Application for Removal or Variation of a Condition following Grant of Planning Permission or Listed Building Consent

Installation of a new shop front, provision of balcony with 1.1m high privacy screen to rear 2nd floor, installation of roof lantern to rear and use as altered as retail and office space at ground floor and 2 serviced holiday flats to 1st and 2nd floors

23/0411

Condition 2: Change approved drawings: A023/061/BR/02 Revision A to A023/061/BR/02 Rev B and A023/061/BR/01 Revision D to A023/061/BR/01 Revision E

DRAWING No. A023/06 I/BR/02 Revision B

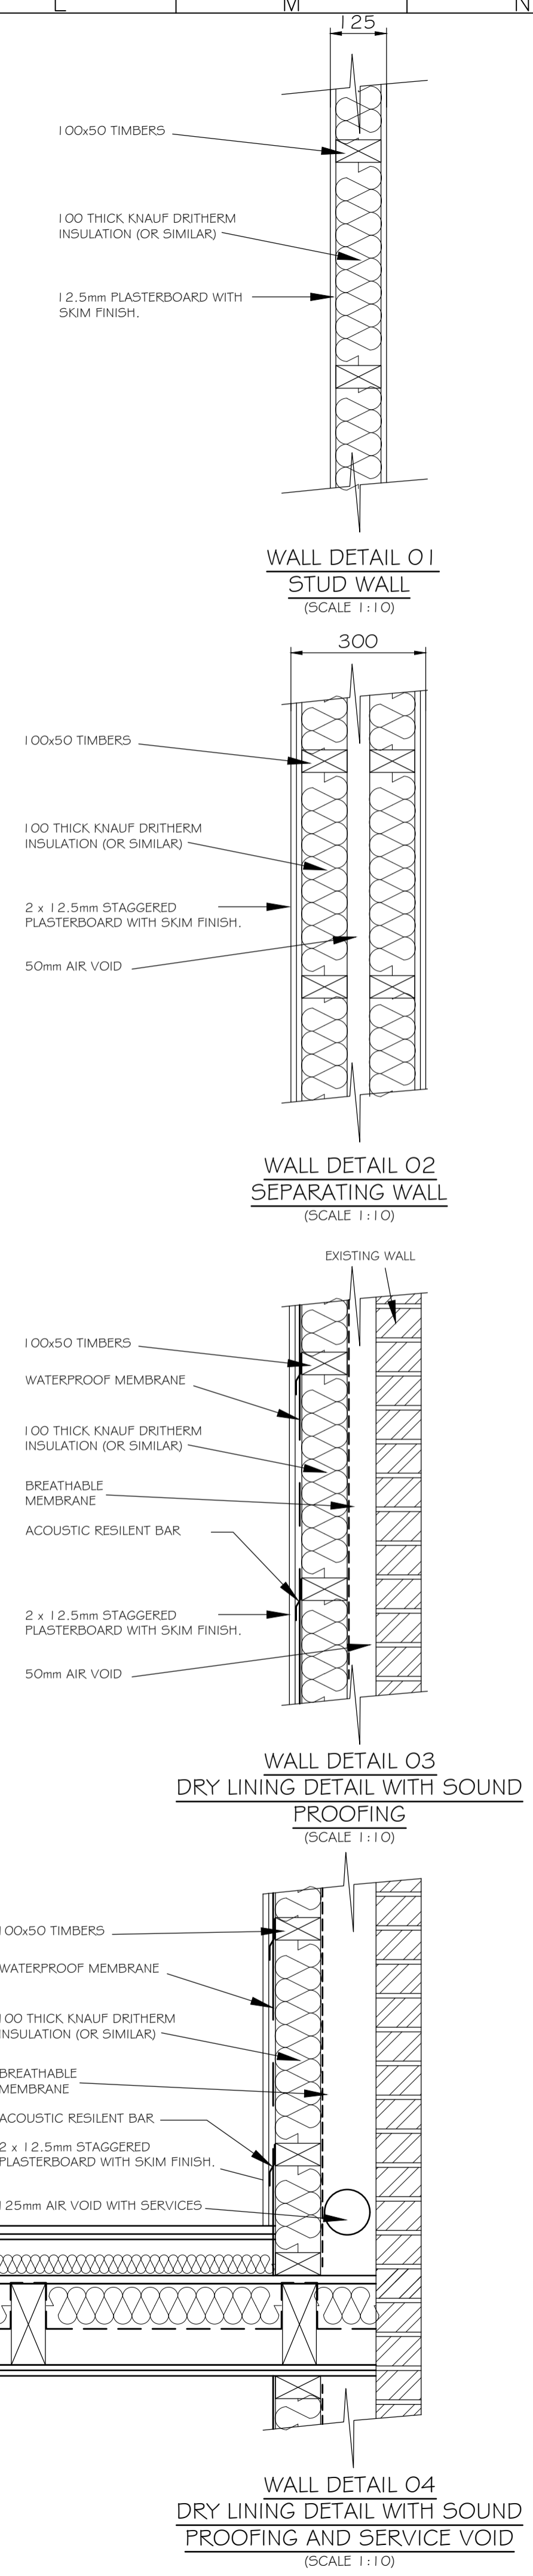
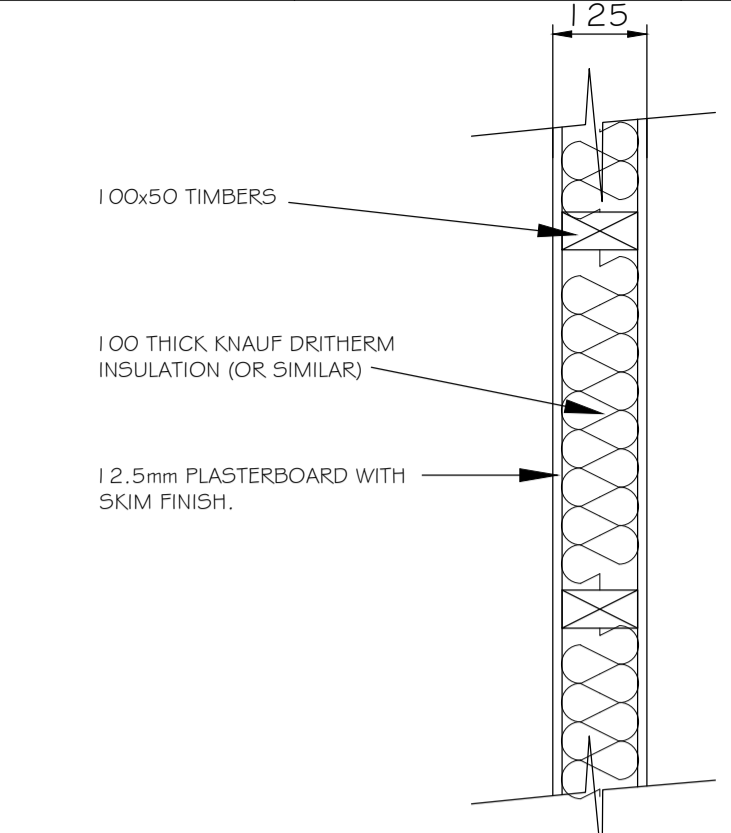
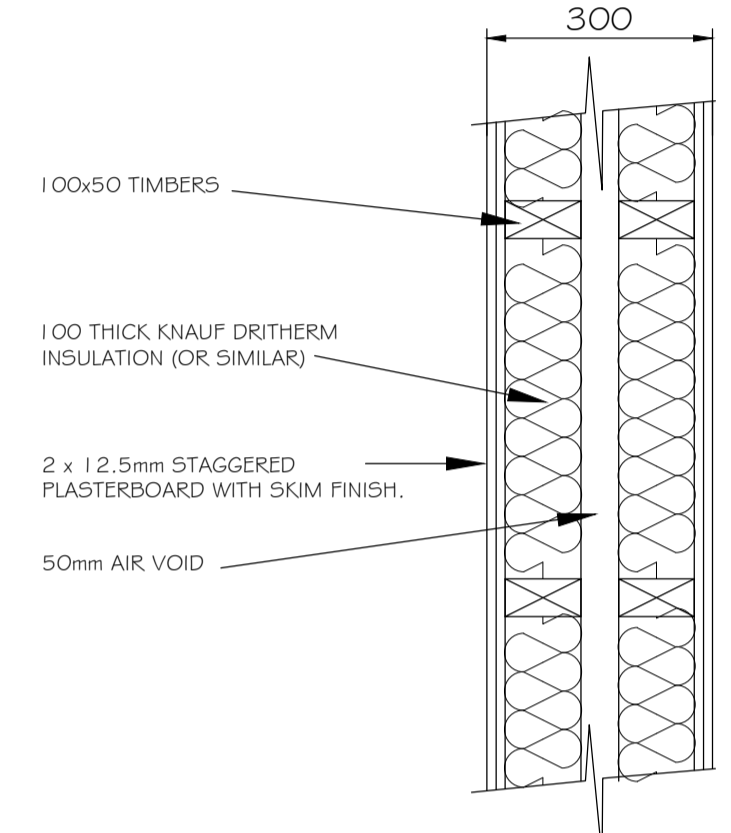
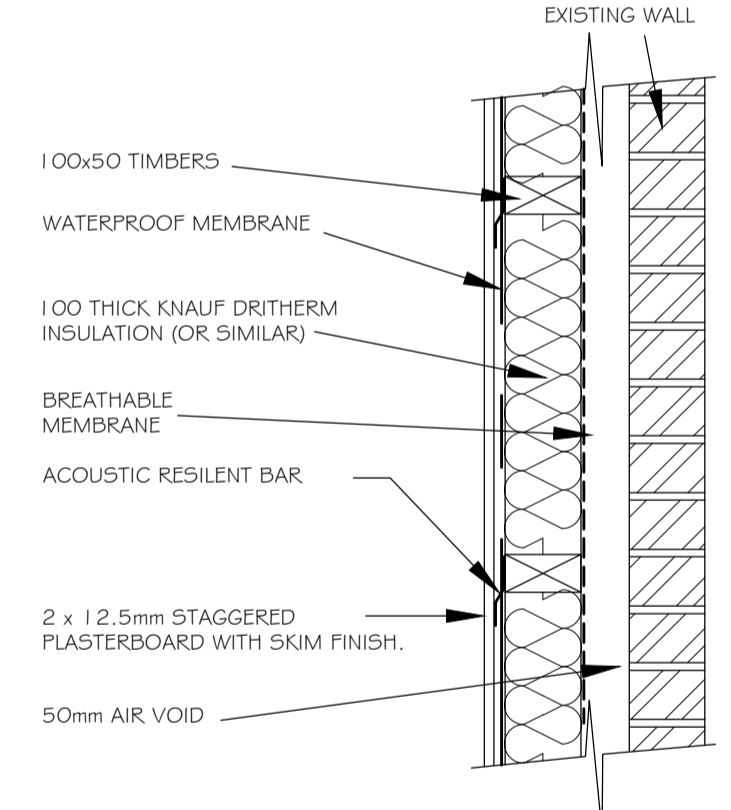
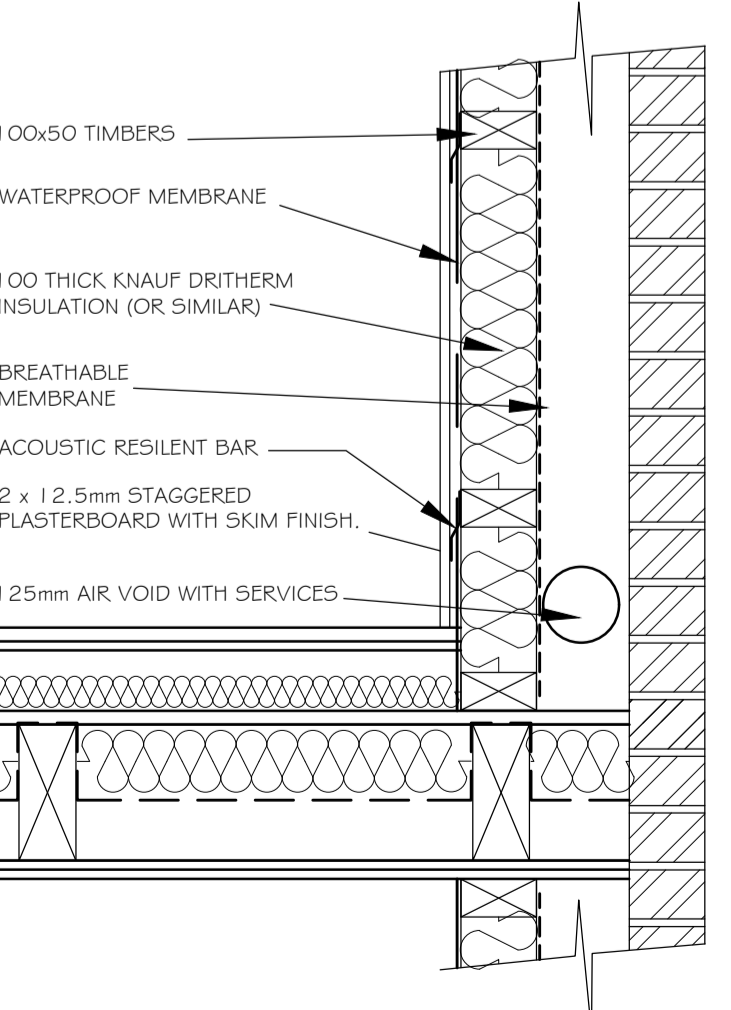
Sub divide the windows to make more user friendly and increase security to the ground floor
